From: [REDACTED]
Sent: 14 January 2019 12:14
To: Planning.Responses
Cc: SU Local Development
Subject: **Warning Active Content** RE: Planning Consultation on Y/102/18/DOC

APPLICATION NO: Y/102/18/DOC

Description of Works: Approval of details reserved by condition imposed under ref APP/C3810/V/16/3158261 relating to Condition No 13 Comstruction Management Plan.

WEST SUSSEX COUNTY COUNCIL CONSULTATION

DRAWING TITLE:
 BUILD SEQUENCE DRAFT

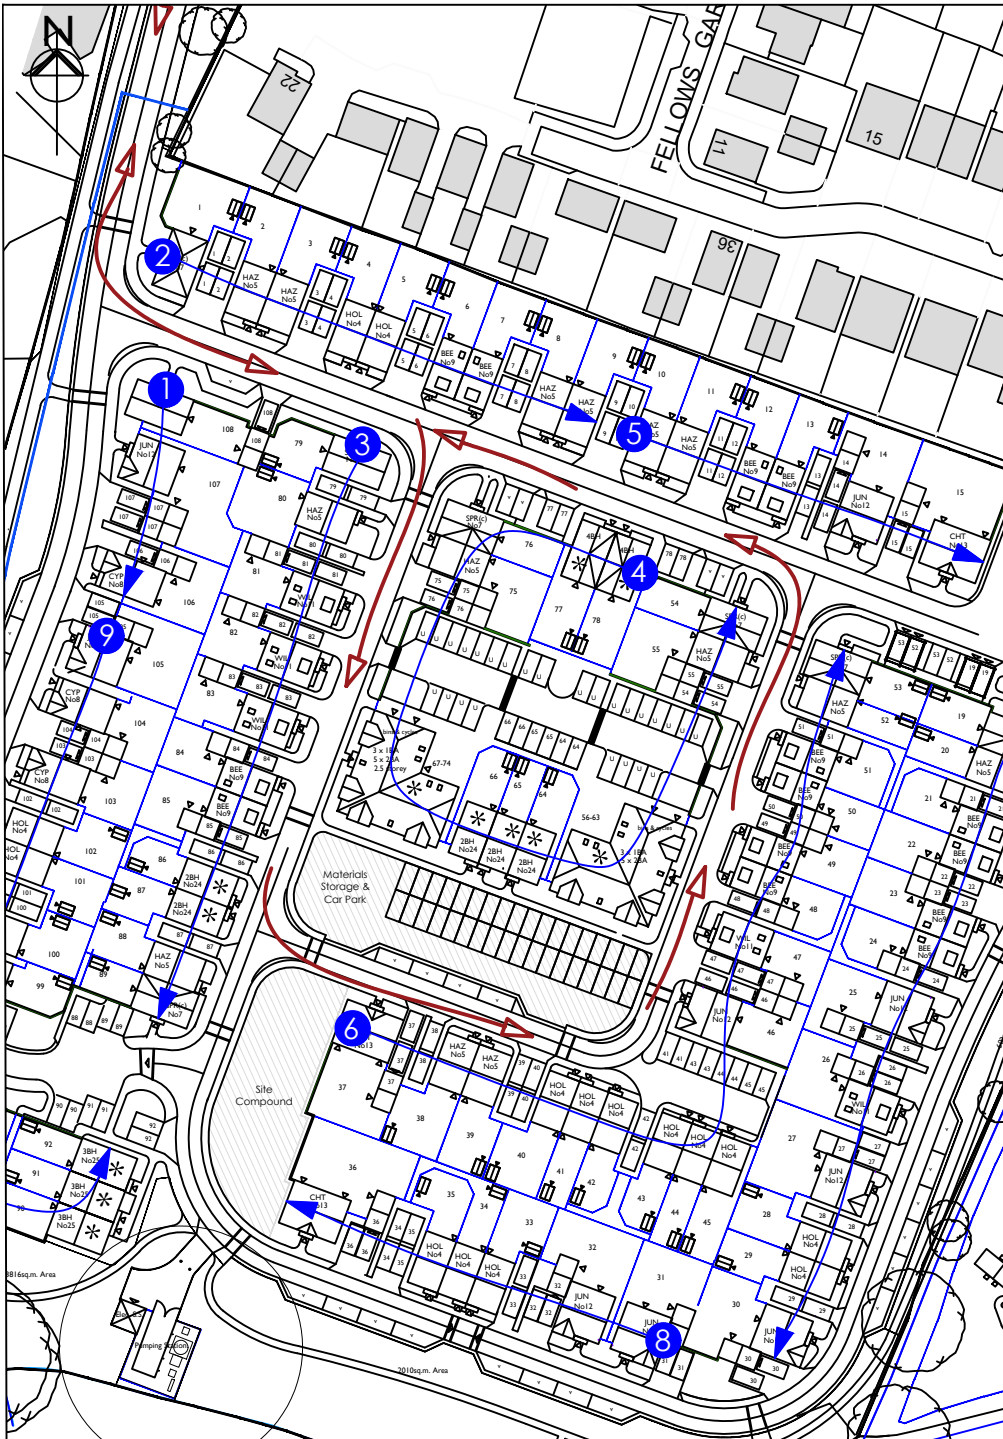
Safe and convenient public access is to be available at all times across the full width of the PROW, which may be wider than the available and used route – advice on the legal width can be provided by the WSCC PROW Team.

The applicant is advised that a public access right has precedence over a private access right. Should a closure be required as intimated in the CMP this must be applied for well in advance in order that WSCC as Highway Authority may consider the proposal.

The path is not to be obstructed by vehicles, plant, scaffolding or the temporary storage of materials and / or chemicals during any works. These will constitute an offence of obstruction under the Highways Act 1980.
